From: Laura Gibbons
Sent: 21 February 2019 15:56
To: 'Katherine Jenkins'
Cc: Andrew Wood
Subject: RE: Planning Application FG/220/18/PL : Land adjacent to Elm Lodge, Tamarisk Way, Ferring, West Sussex BN12 5ER

Laura Gibbons, MEng, GMICE
Engineer (Drainage & Coastal)

1. Please identify whether a pipe exists at the western extent of the pond. This will impact upon if I believe there is a likelihood you will have sufficient space for surface water drainage. The soakaway that you are currently proposing is located directly on top of the suspected pipe location. We will be able to identify the location of any potential pipe as part of a pre-commencement condition. We agreed that we could also submit details of proposed soakaway locations as part of the pre-commencement conditions relating to surface water drainage, once potential for soakaways had been adequately assessed, calculated and positioned by a civil engineer. It is likely the 100mm diameter soakaway pipes would be at a higher level if crossing over any existing pipe from the pond, therefore may not impact any existing pipe, although we would ensure this is checked by a civil engineer and approved by ADC as part of the pre-co

EXISTING POND ACCESS
PLAN

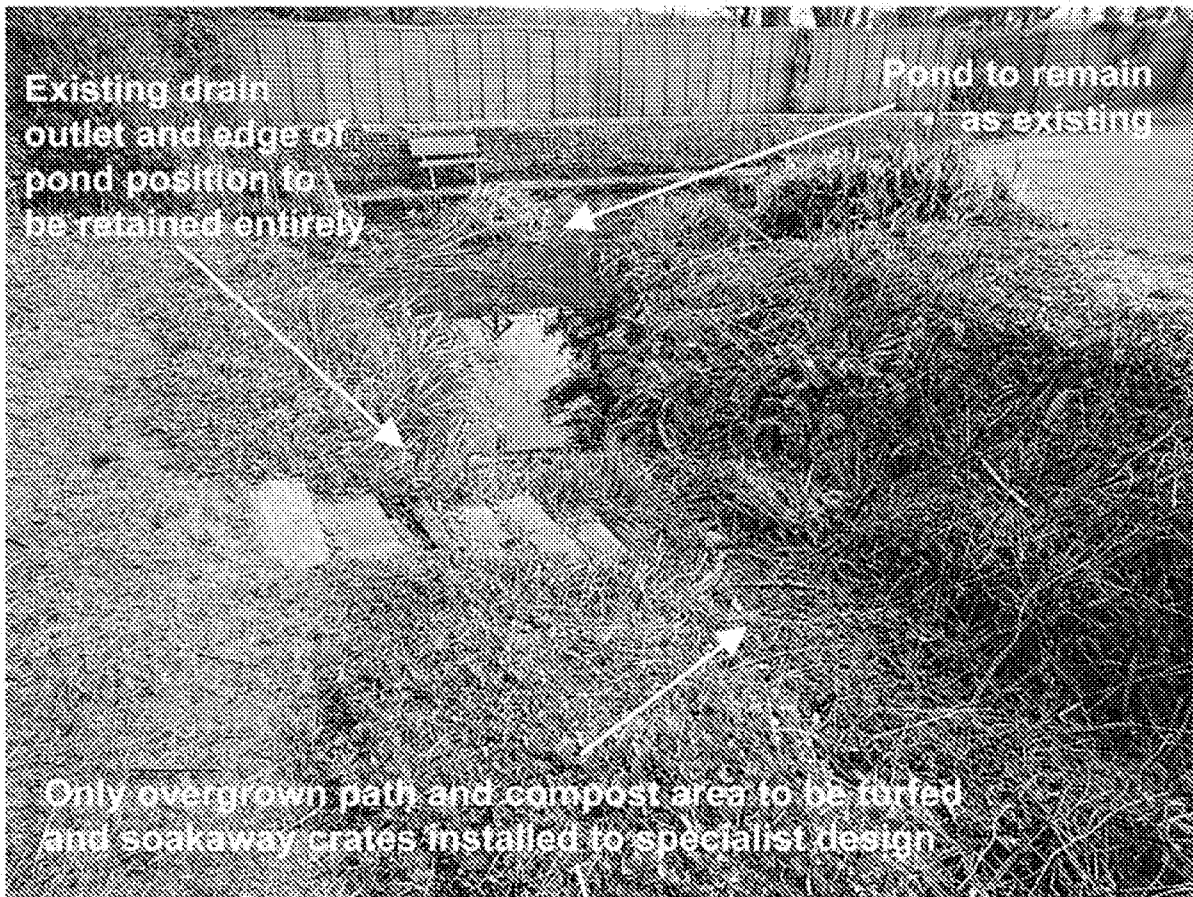
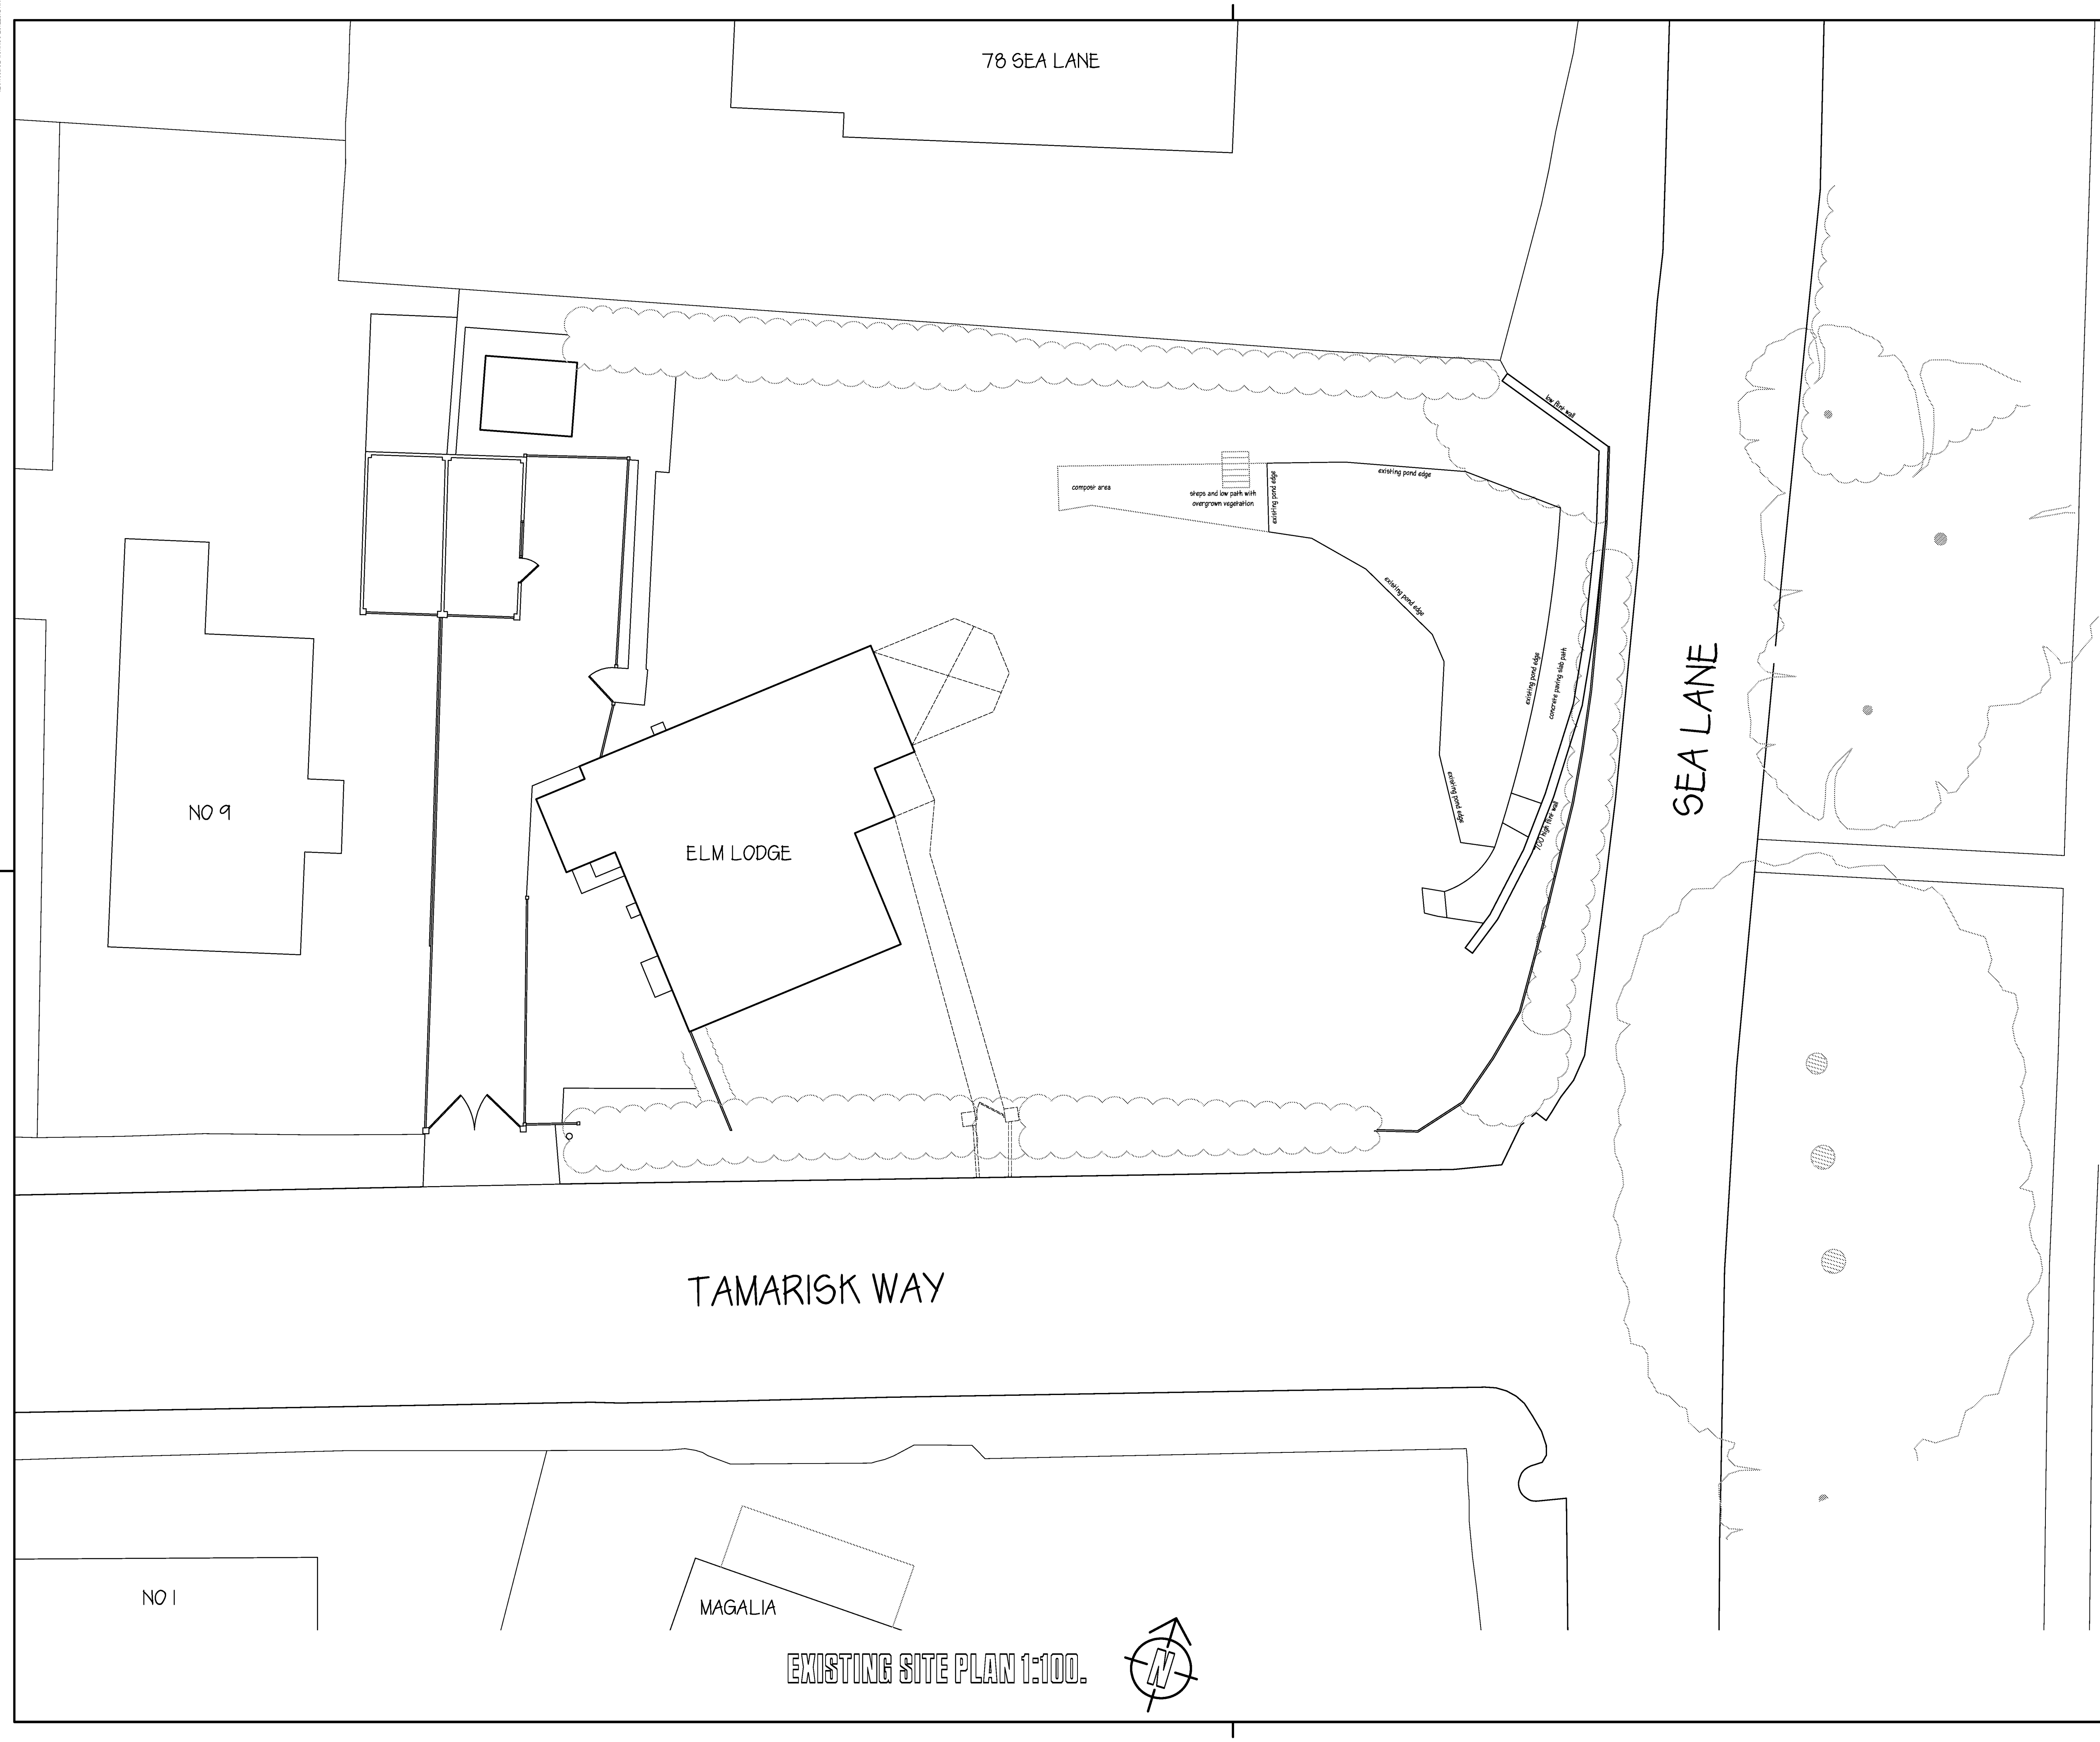
3. It is my belief that there is no way to get to the northern and western portions of the pond without tracking through the pond itself. This would mean that maintenance would have to be completed in the summer by the landowner when water levels are lower. This would then be within nesting bird season. I would much prefer an access to be provided around the pond. I note that you state the 1m wide path to the east could take plant but this plant would not be big enough. As explained above, we as landowners can continue to access the pond from all sides, with 3m to the West, North and South East. We cannot understand what plant would ever be required (given no plant has ever needed to access the pond before, and any plant necessary for carrying out works to the pond can have full access from all sides as part of the building works) that would ever be larger than a small digger, which can easily be maneuvered up the 1m side access to the west of site and around the rear. You are going to need a large digger to access the pond and clear it of vegetation and silt. The size of machine is dictated by the depths that excavation need to be carried out to, the size of plant that can fit along a 1m path would not be sufficient to carry out the excavation required. Ongoing maintenance will be required after construction is complete, this is when the proposed site layout in my opinion would prevent this work.

Further to our meeting at the land adjacent to Elm Lodge, Tamarisk Way, Ferring, West Sussex BN12 5ER on 12th February 2018, please find attached the existing and proposed pond access plans as requested. These show the existing pond to be retained in its entirety, with 3m access provided should Arun District Council ever need to access our property to maintain the pond. We hope these now alleviate your concerns regarding potential future access. We also note that the path to the east of the pond is also over 1m wide, which can currently comfortably accommodate a 1.5 ton digger to carry out any works. Given that there are multiple points of entry along the edge of the pond, any further work can be carried out from within the pond.
